Recommendation Report for Planning Permission for Works or Extension to a Dwelling

REF NO: LU/143/26/HH

LOCATION: 24 The Estuary
Littlehampton
BN17 6NE

PROPOSAL: Erection of a single storey outbuilding.

ELEVATIONS

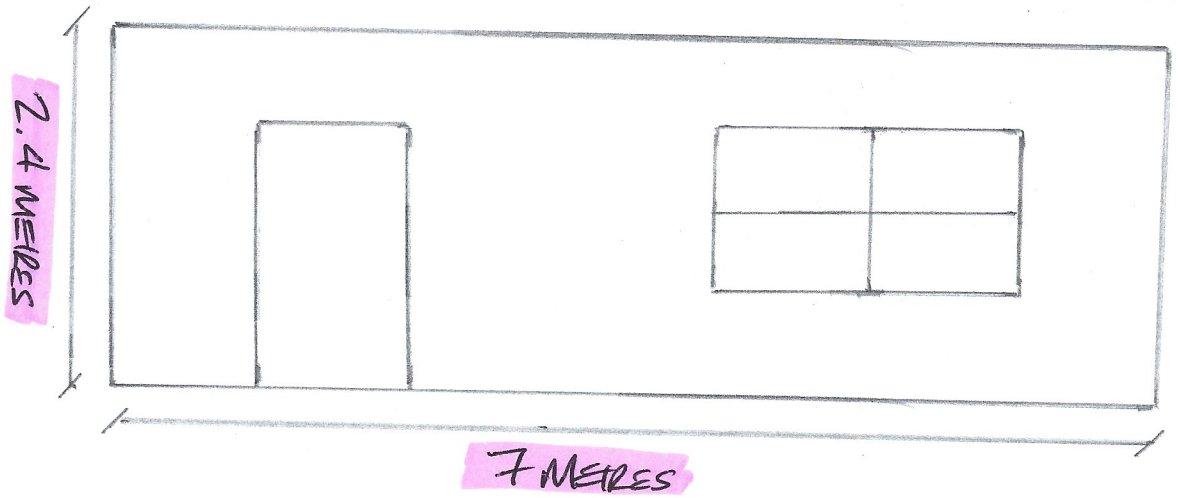
The proposed single storey outbuilding would have a width of 7m, a depth of 4m and a height of 2.4m, with a flat roof. The outbuilding would be to the front of the application site and would not appear fully subservient to the host dwelling. Nevertheless, there are other examples of built form and projections close to front boundaries in the surrounding area, although these are attached to their host dwellings. As such, the proposed outbuilding would not appear unduly prominent within the street scene and it would not result in demonstrable harm to visual amenity.

Fenestration would be confined to the eastern elevation facing the host dwelling's rear garden amenity space and would include one door and one window. These would be uPVC to match the host dwelling. The outbuilding would be finished in brick to match the host dwelling and would have an Ethylene Propylene Diene Monomer (EPDM) flat roof. The use of the proposed materials ensures the proposed single storey outbuilding integrates appropriately with the host dwelling and preserves its character, in accordance with Arun Local Plan (ALP) policy D DM1 and the Arun Design Guide (ADG).

ELEVATIONS

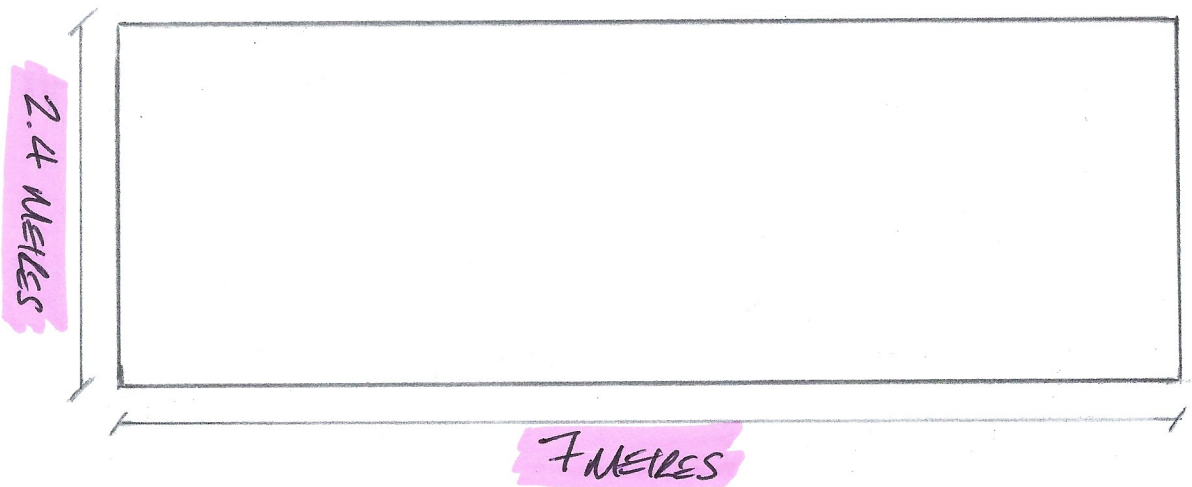
The single storey outbuilding would be set in from the western side boundary by 1m and the southern rear boundary by 1.5m. It would be positioned opposite the rear neighbour's driveway area. Given its modest height of 2.4m, separation from the boundaries and existing soft landscaping, it would not result in an unacceptable overbearing or overshadowing impacts to neighbouring amenity.

Fenestration would be limited to the eastern elevation, facing towards the host dwelling's rear garden amenity space. As such, the proposal would not result in overlooking or loss of privacy to neighbouring occupiers.
